APPENDIX A DETAILED RESPONSE TO AGENCY SUBMISSIONS AND DEPARTMENT OF PLANNING, INFRASTRUCTURE AND ENVIRONMENT LETTER

Ethos Urban and Infrastructure NSW

8 October 2020

Appendix A – Response to Submissions

Southern Elevation - Signage Zone

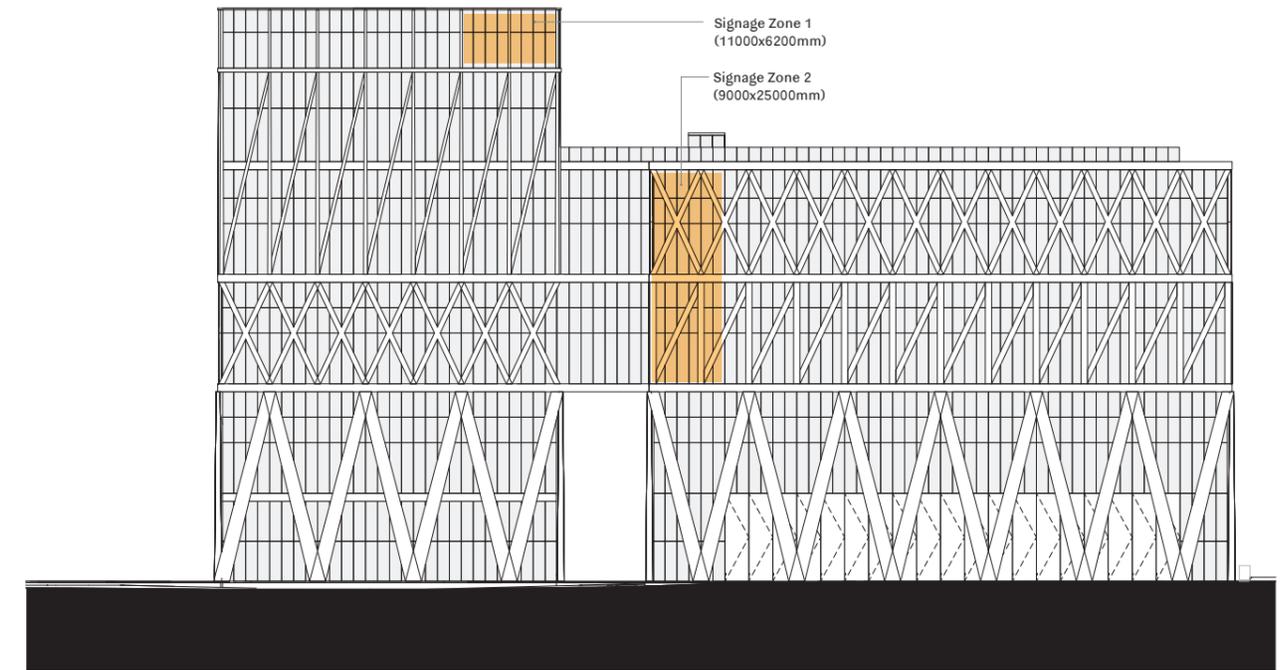
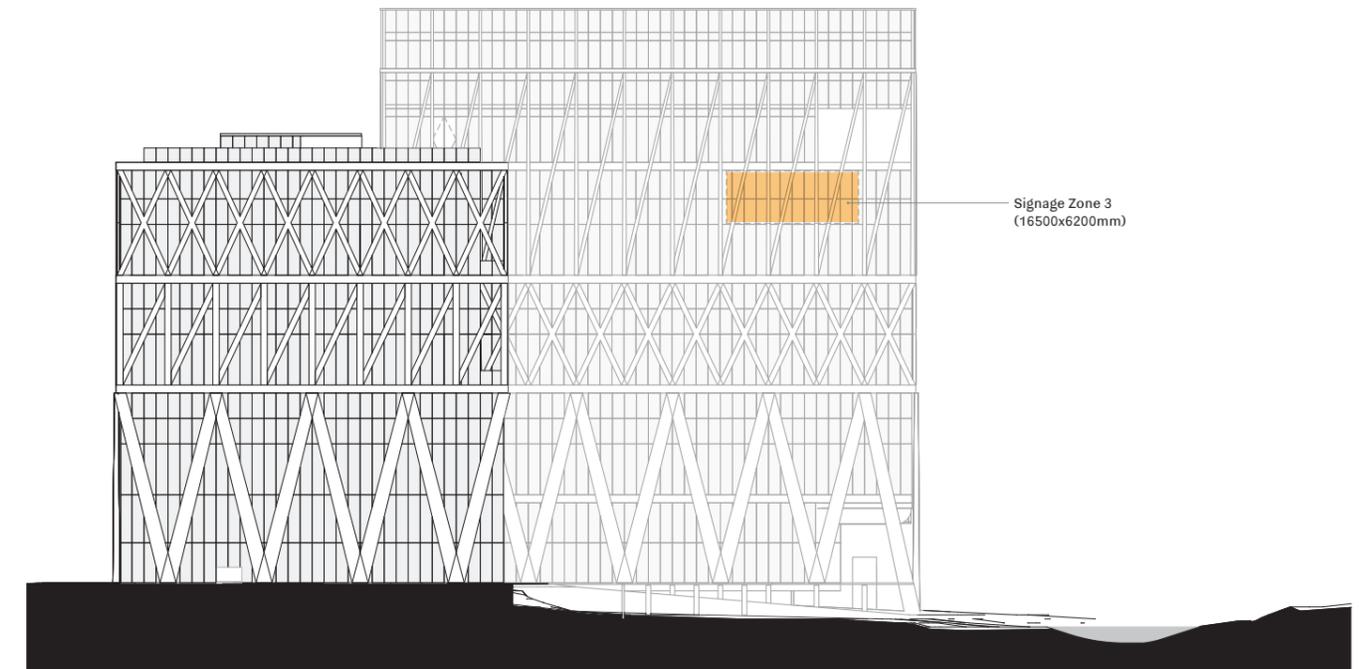
DPIE5	Further consideration should be given to the building's interface with Phillip Street and Wilde Avenue, to ensure the proposal activates those frontages and provides an appropriate address to the Parramatta CBD.	Refer to the Architectural Design Report Addendum which addresses the design intent of the façade, and the Landscape Report Addendum which addresses the activation of the Phillip Street frontage, including address to the Parramatta CBD, at Appendices B and C of the RTS Report respectively.
DPIE6	Further consideration should be given to the loading/unloading and drop off/pick up requirements of the proposal, with options explored to reduce the prominence of loading areas in the public domain, minimise pedestrian conflicts and ensure safe and convenient access.	Consideration has been given to the site access strategy to limit the extent of vehicle manoeuvring within the public domain as well as to provide appropriate servicing arrangements for the museum. A key aspect of the transport strategy is to minimise, wherever possible, the volume of vehicular traffic entering the site to provide the safest and most amenable pedestrian environment. With respect to the selection of a suitable vehicle access point there are a number of existing constraints that has informed the design, those being:
